Project #: 1003479

Project Name: LAND OF ST ANTHONY ORPHANAGE

DEVELOPMENT REVIEW BOARD MEETING – May 1, 2013

INTER-OFFICE MEMO

1 WEST ELEVATION
1/8" = 1'-0"

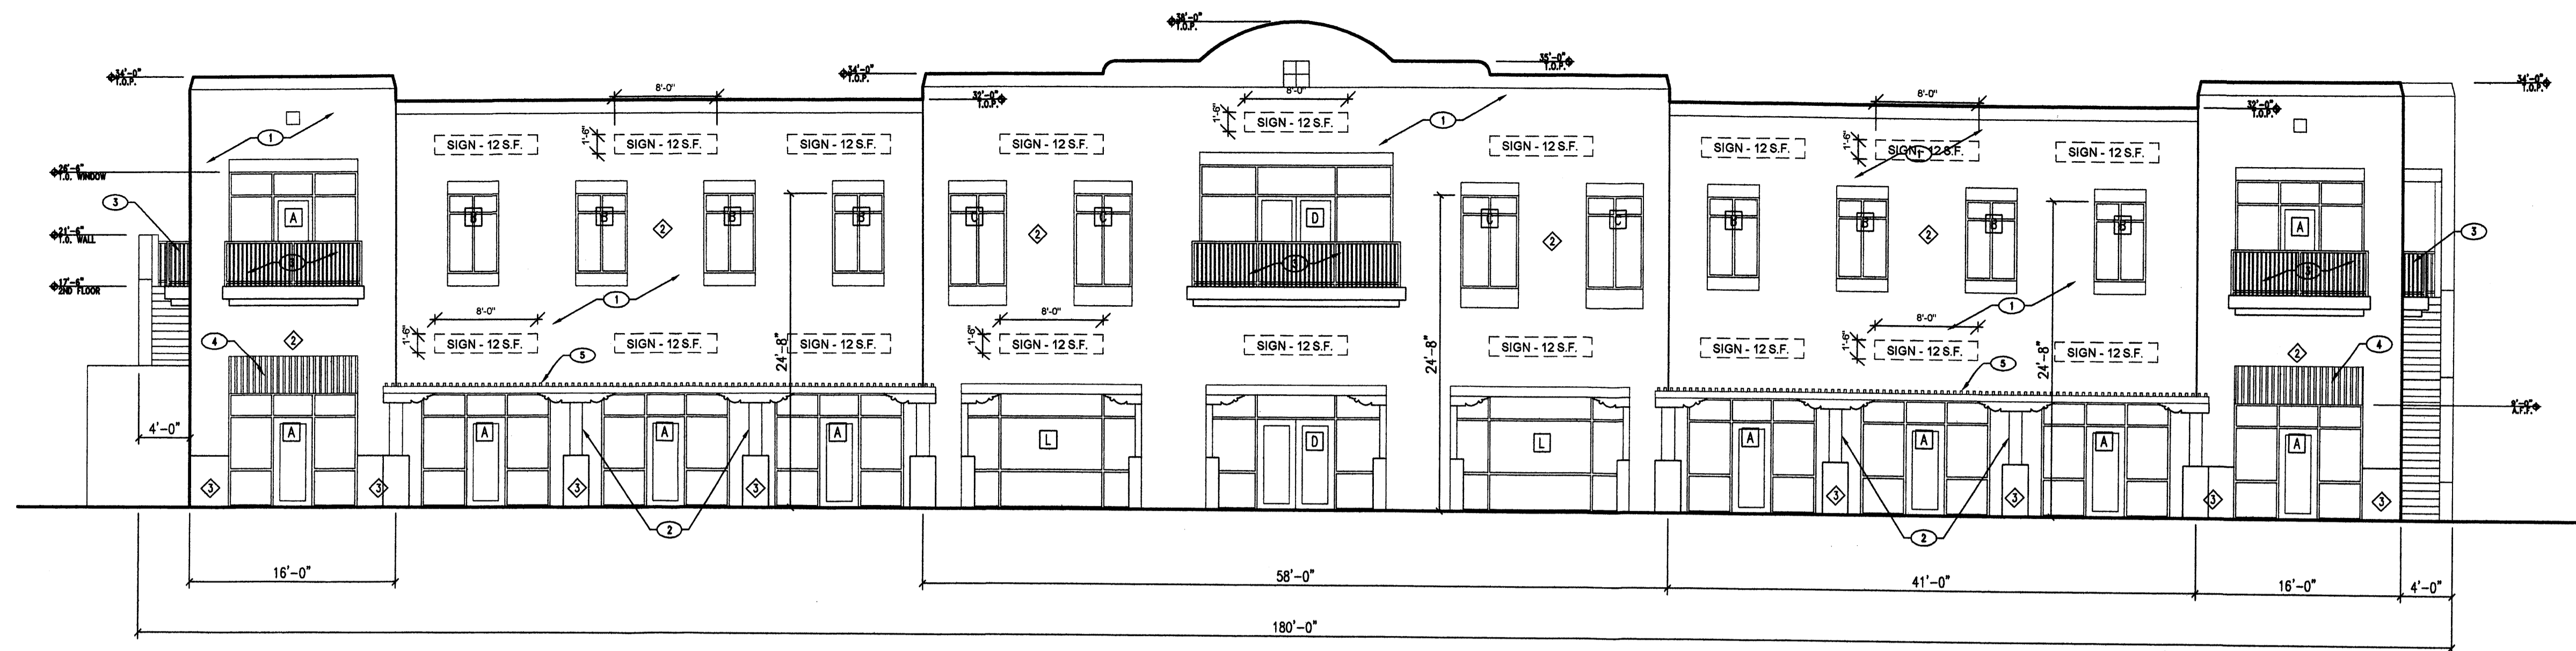
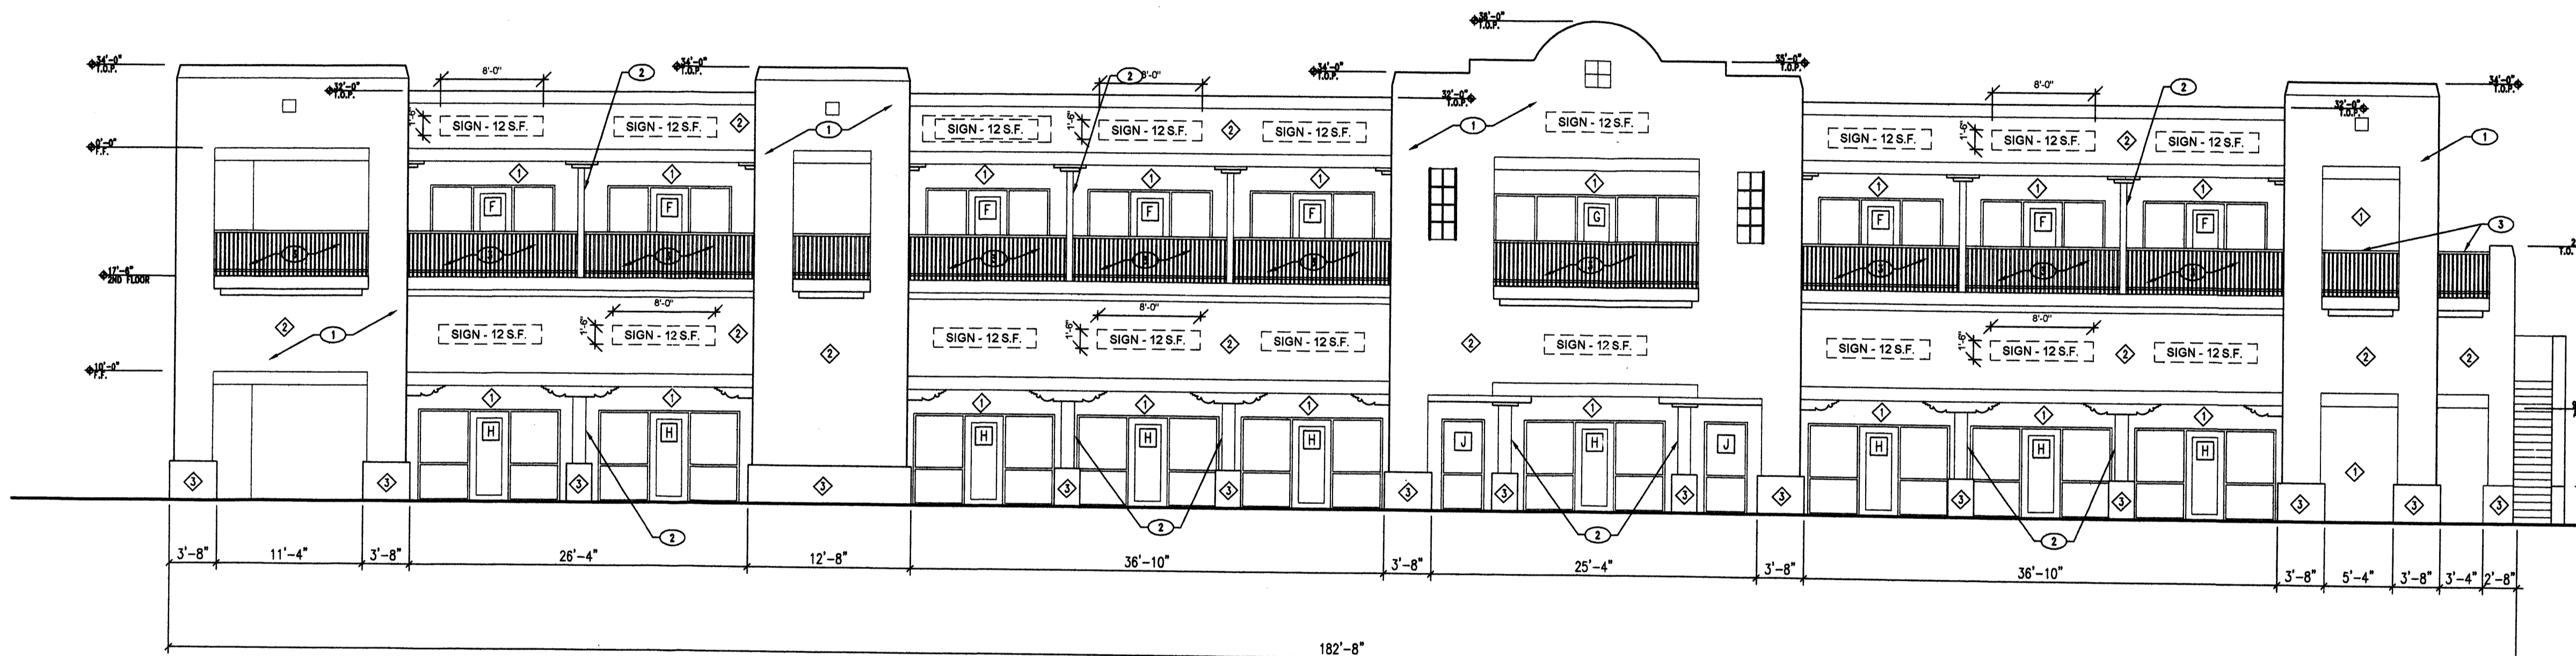
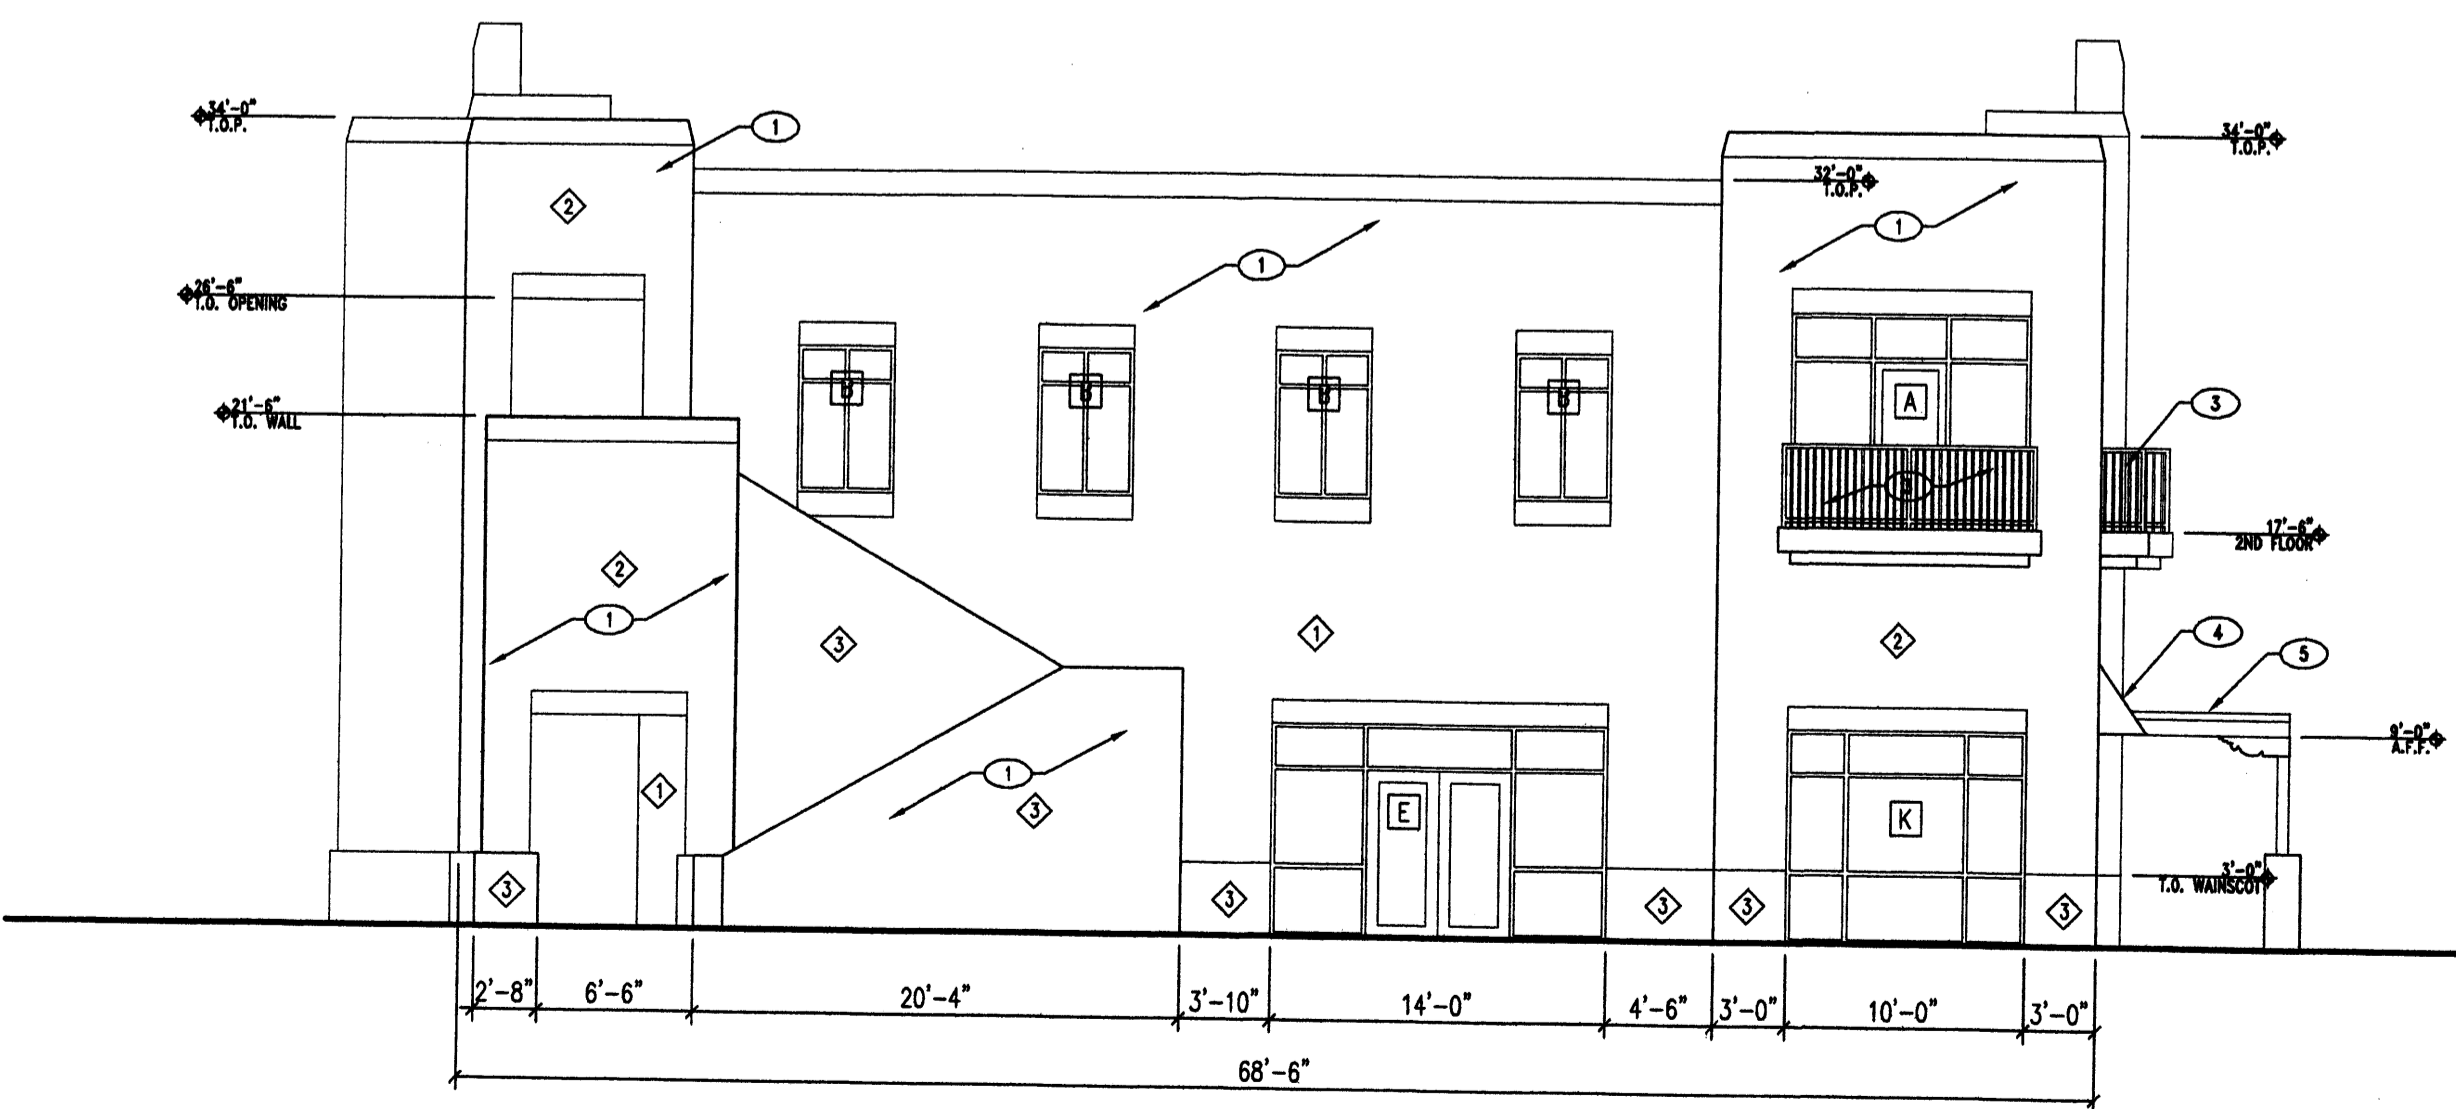
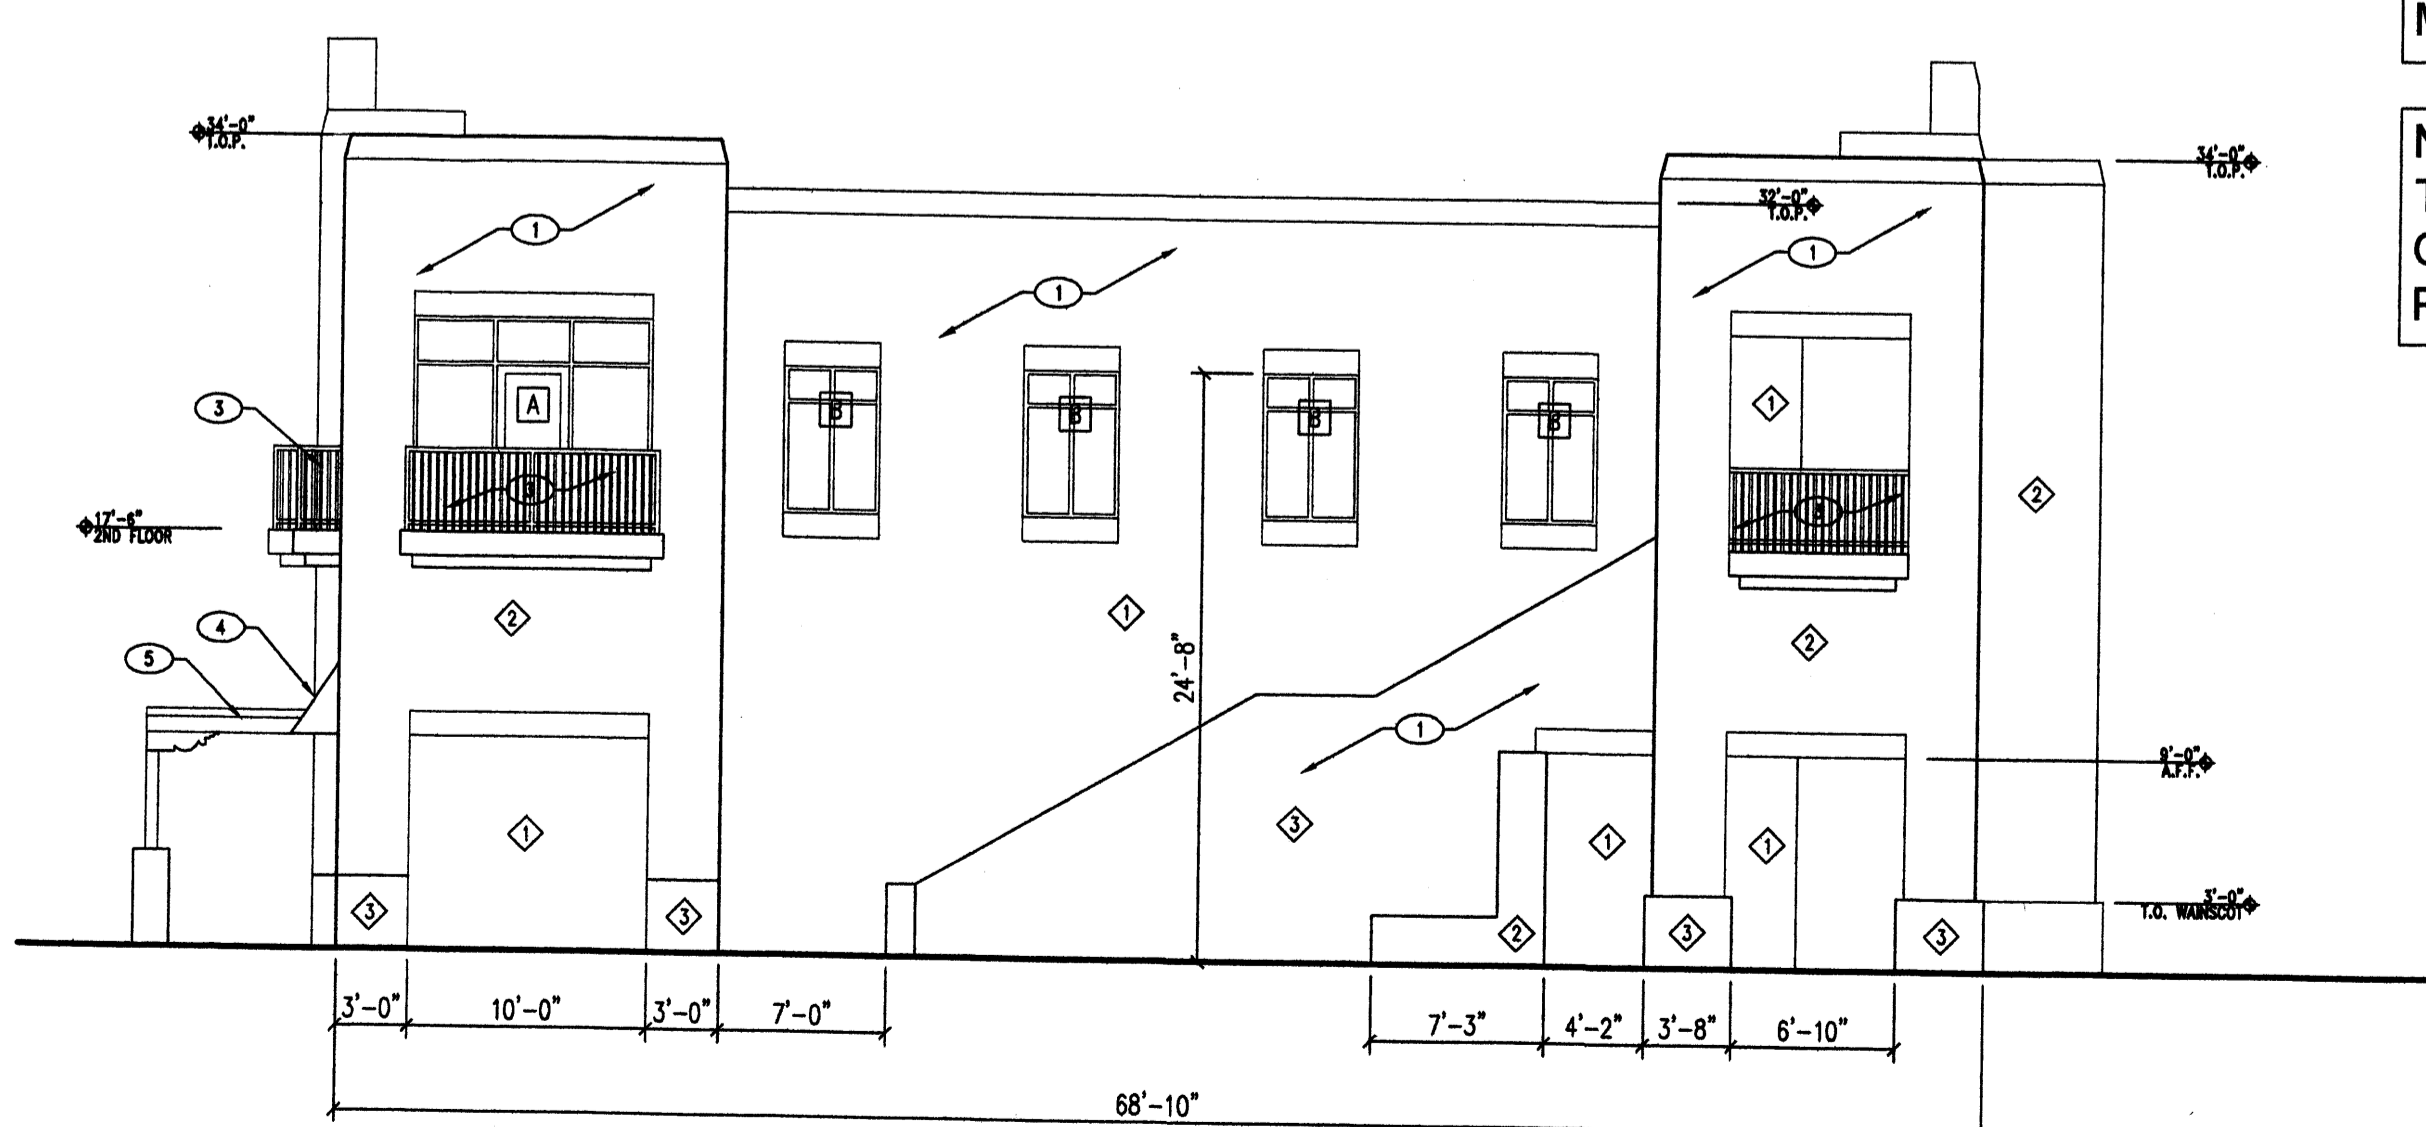
A note needs to be added to the last, boxed note on the first page of the elevations to indicate that the tenant signs on the east side of the building shall be of metal channel letters.

A note needs to be added after the last, boxed note to indicate that illuminated plastic panel signs are not allowed.

A note needs to be added after the last, boxed note to indicate that signs should identify only the name and business of the occupant or of those offering the premises for sale or lease.
